Project Name: UNITY ADDITION

DEVELOPMENT REVIEW BOARD MEMO

DRB CASE NO/PROJECT NO: 1007383

Plat Approval

# PLAT OF TRACT 1, BLOCK 4, UNITY ADDITION

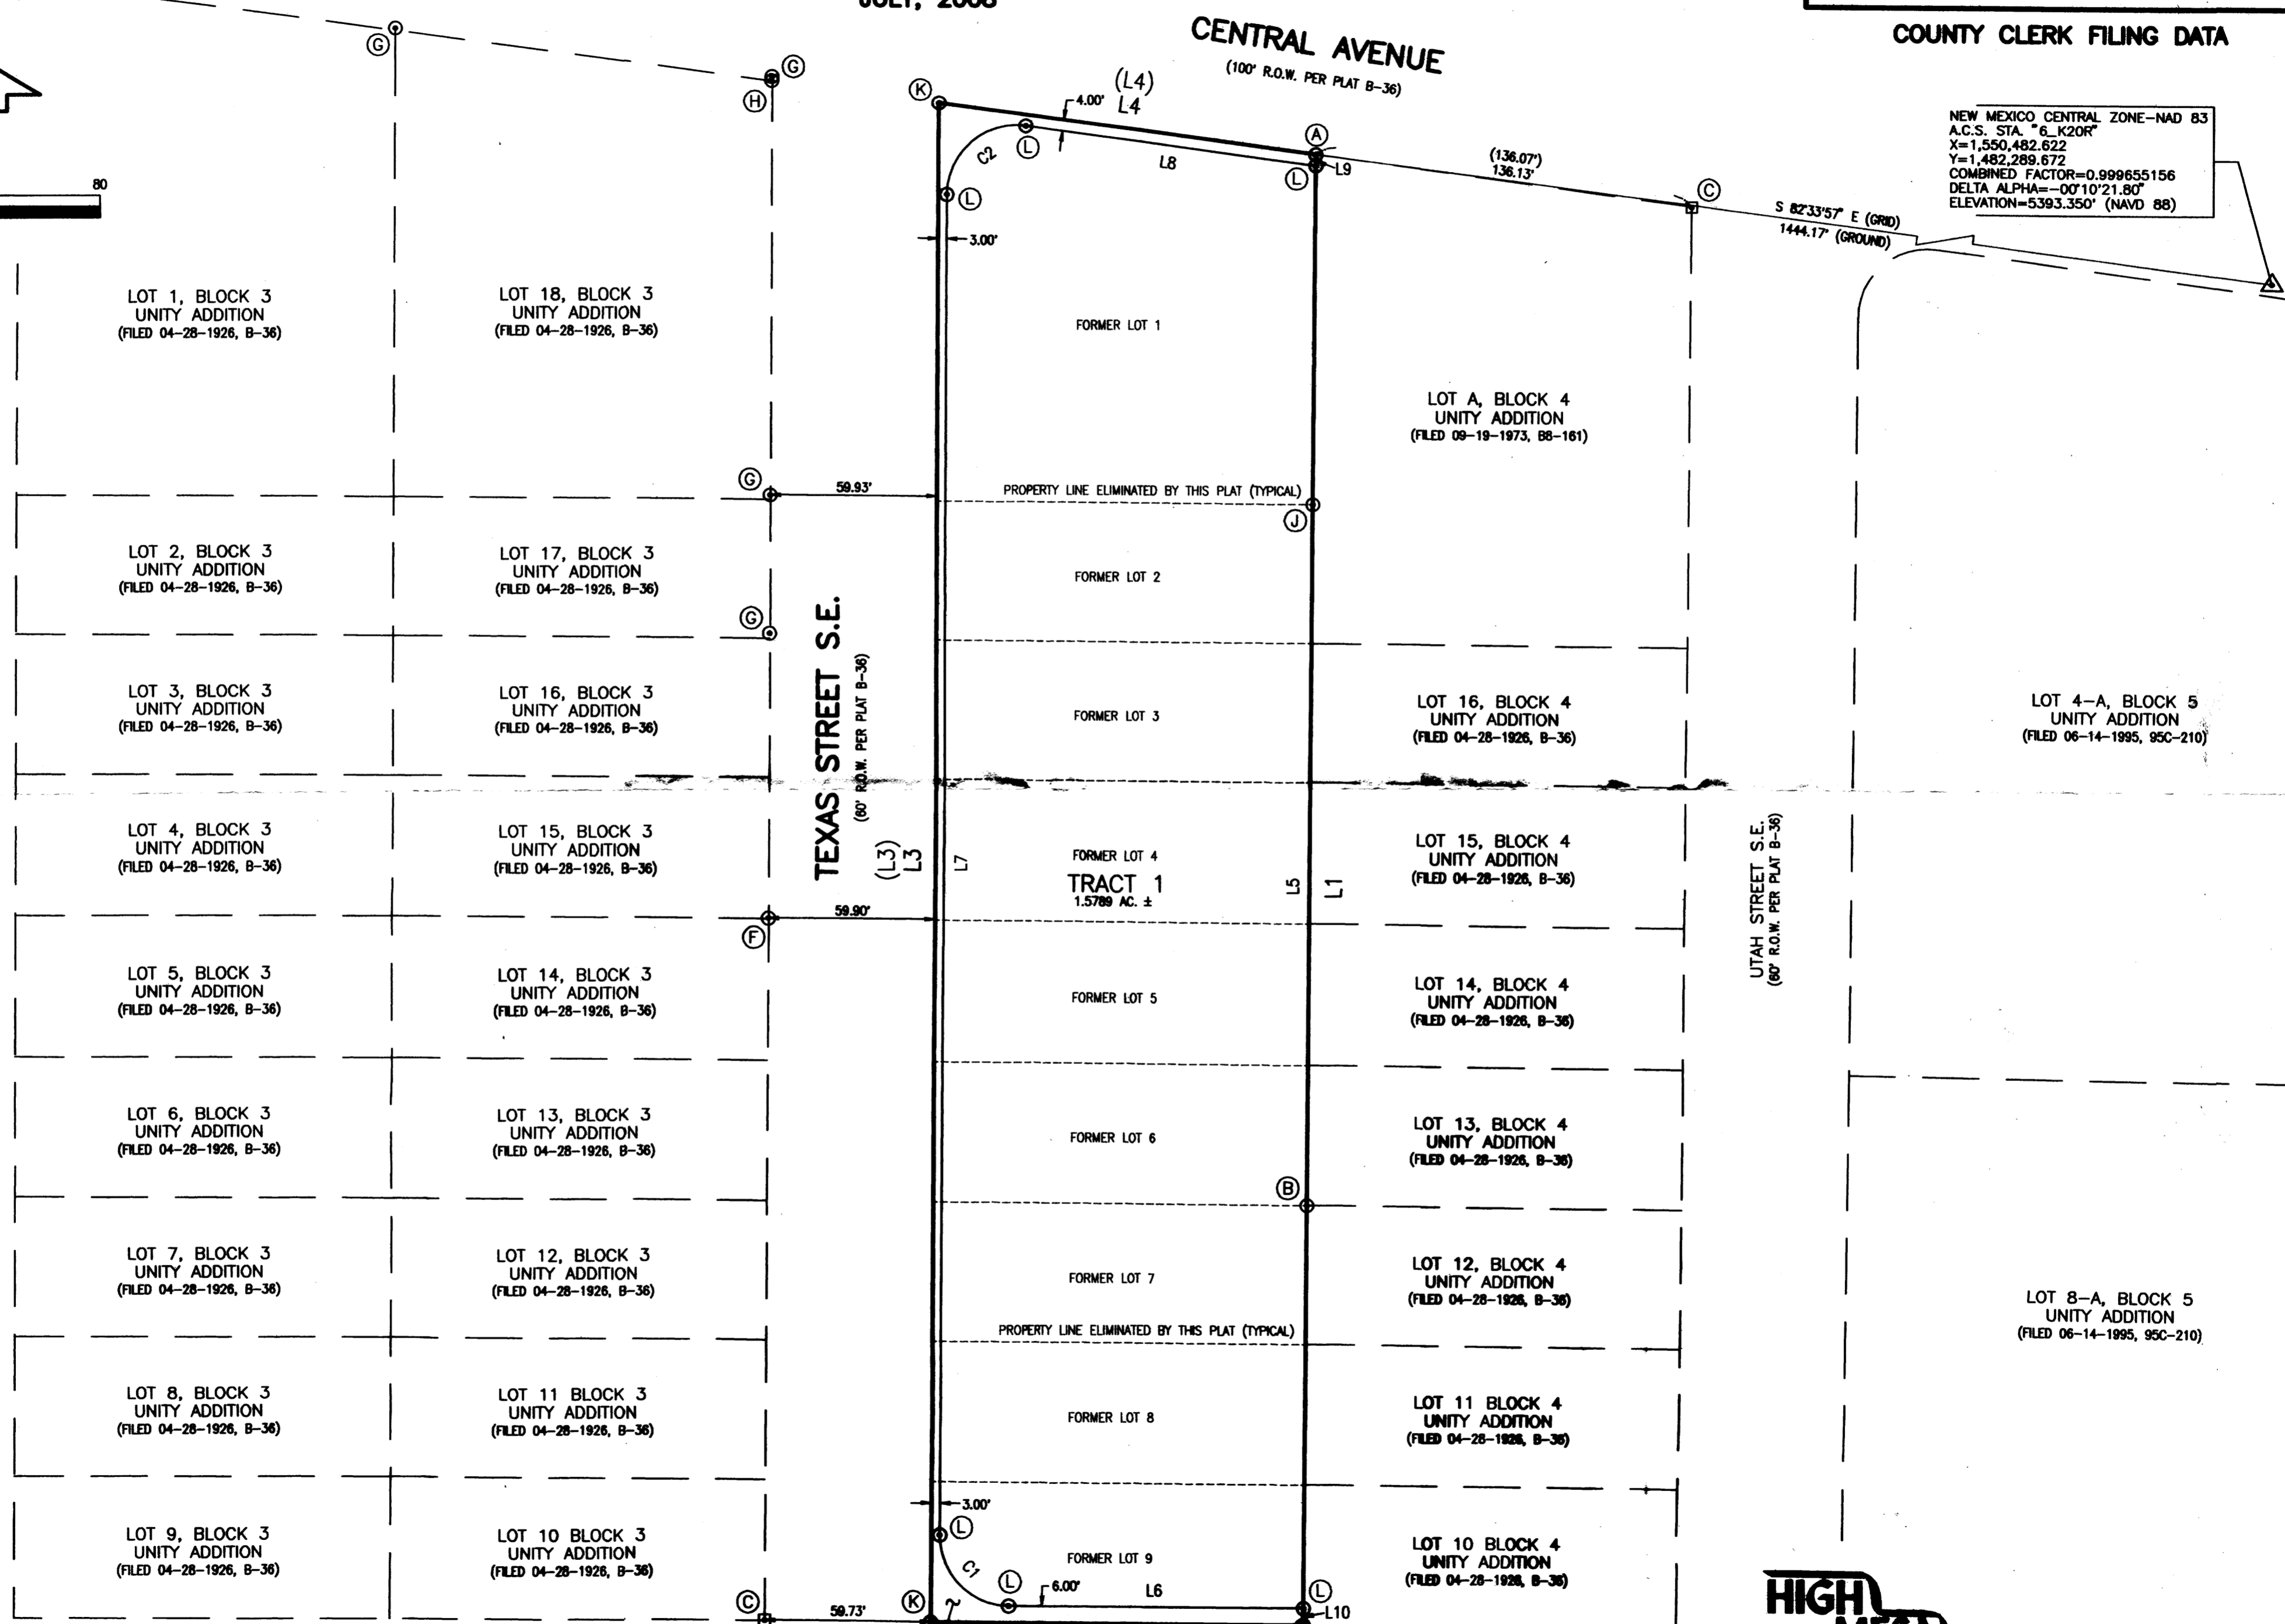
Plat needs to show the AO Flood Zone. Note 4 could be modified to include when the new FIRMs are released (9-26-08) the AO Flood Zone will not exist on this Tract.
